From: Clear, Gwen (ECY) <GCLE461@ECY.WA.GOV> on behalf of ECY RE CRO SEPA COORDINATOR <CROSEPACOORDINATOR@ECY.WA.GOV>
Sent: Monday, April 15, 2013 9:53 AM
To: Jeff Watson
Subject: RE: SP-12-00008 Barnes Notice of Application

RE: Barnes Short Plat SP-12-00008

TO: Jeff Watson, Community Development Services
FROM: Christina Wollman, Planner II *cw*
DATE: February 5, 2013
SUBJECT: Barnes Short Plat SP-12-00008

BARNES SHORT PLAT
KITTITAS COUNTY SHORT PLAT NO. SP-12-XXXXX
 A PORTION OF THE NE 1/4 SECTION 5, TOWNSHIP 16 NORTH, RANGE 20 EAST, W.M.,
 KITTITAS COUNTY, WASHINGTON

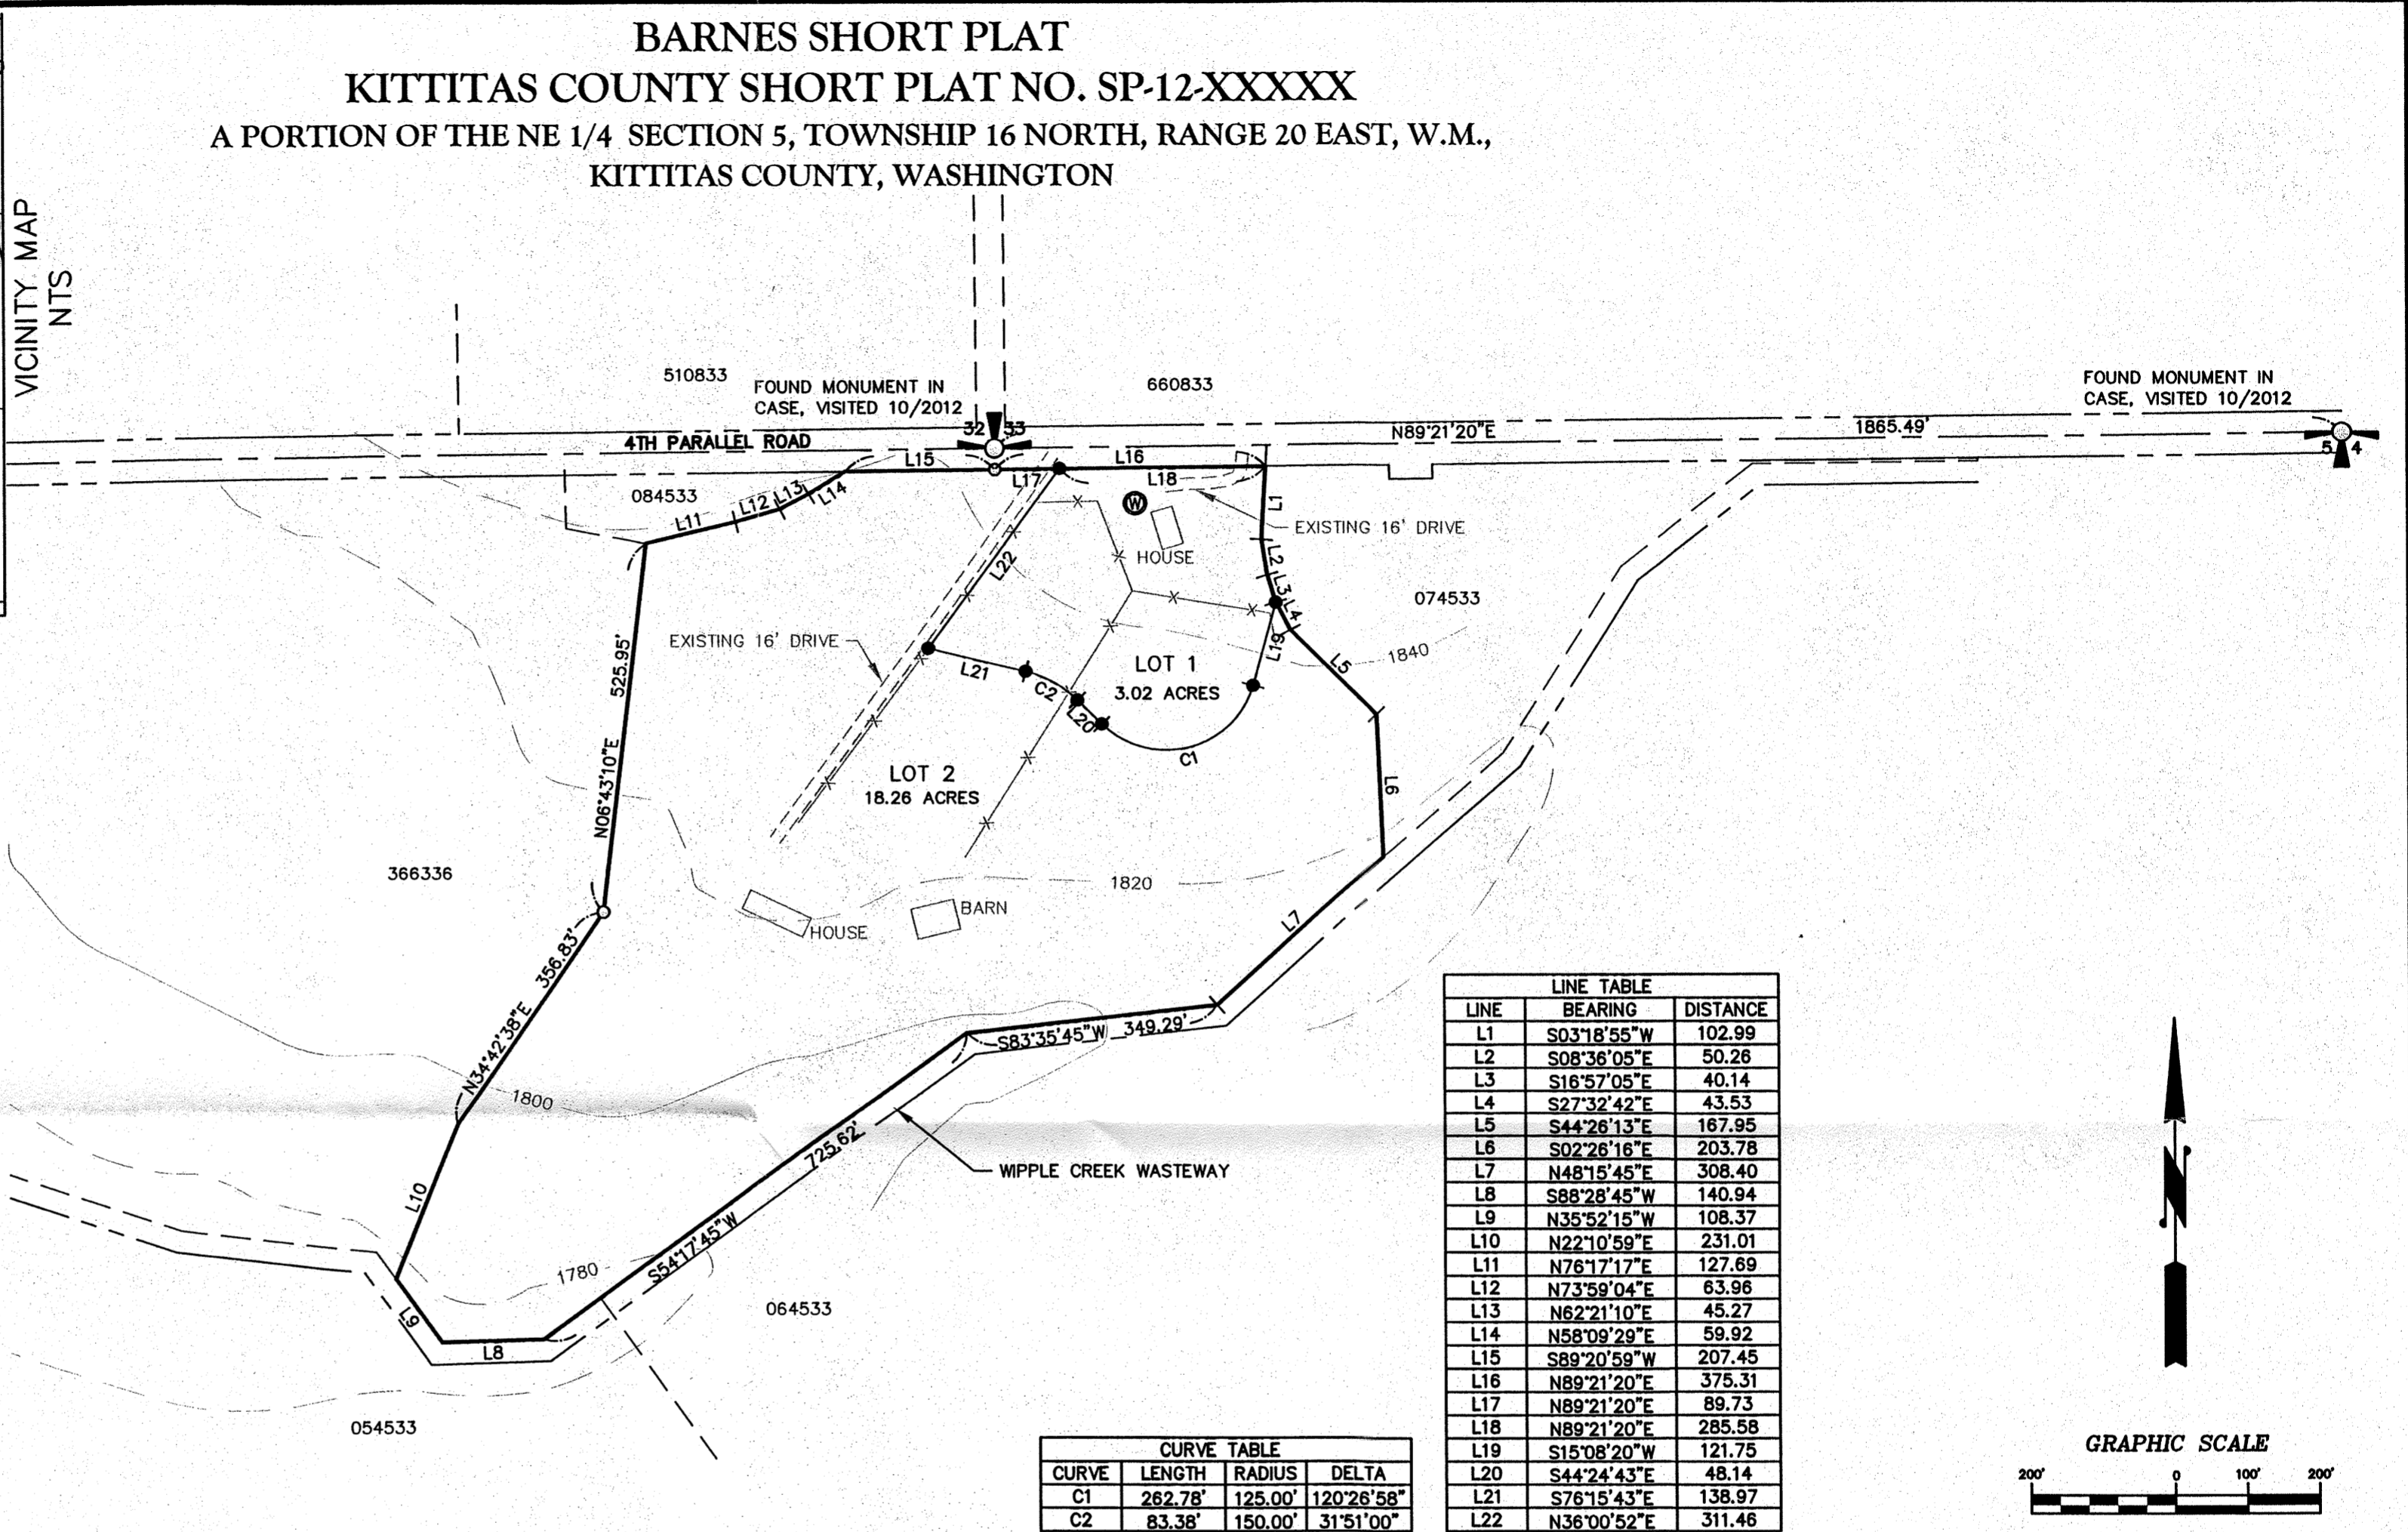
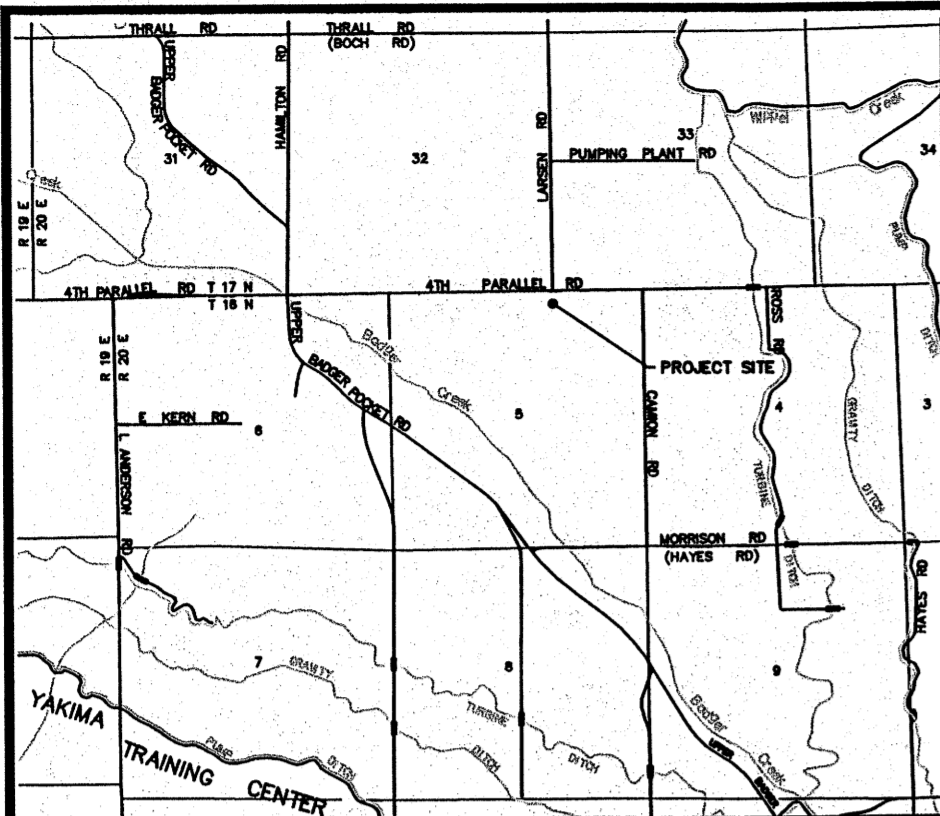
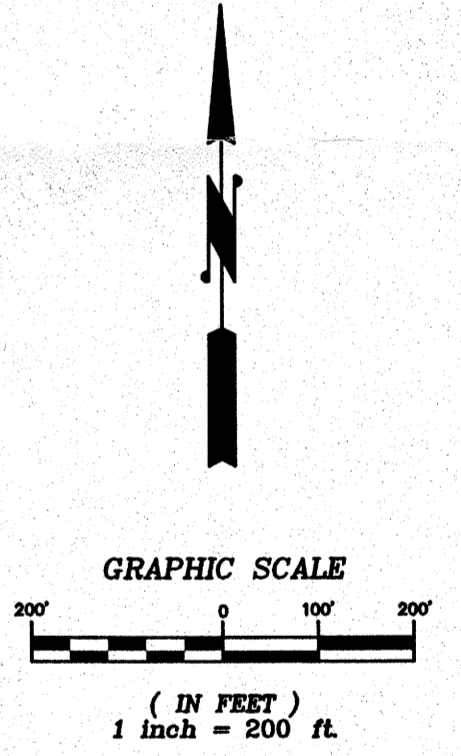
At this point in time this application, it appears that only lot 1 contains a well. If there is another well on lot 2, then that well needs to be identified on the plat map, and meet all adequate water supply requirements as mentioned above. If a shared well is in use, in addition to the adequate water supply requirements, a shared well users agreement will need to be recorded and submitted before KCPHD can recommend final approval. It also appears that both proposed lots have homes located on them. If both homes have permitted septic systems additional soil logs will not be required.
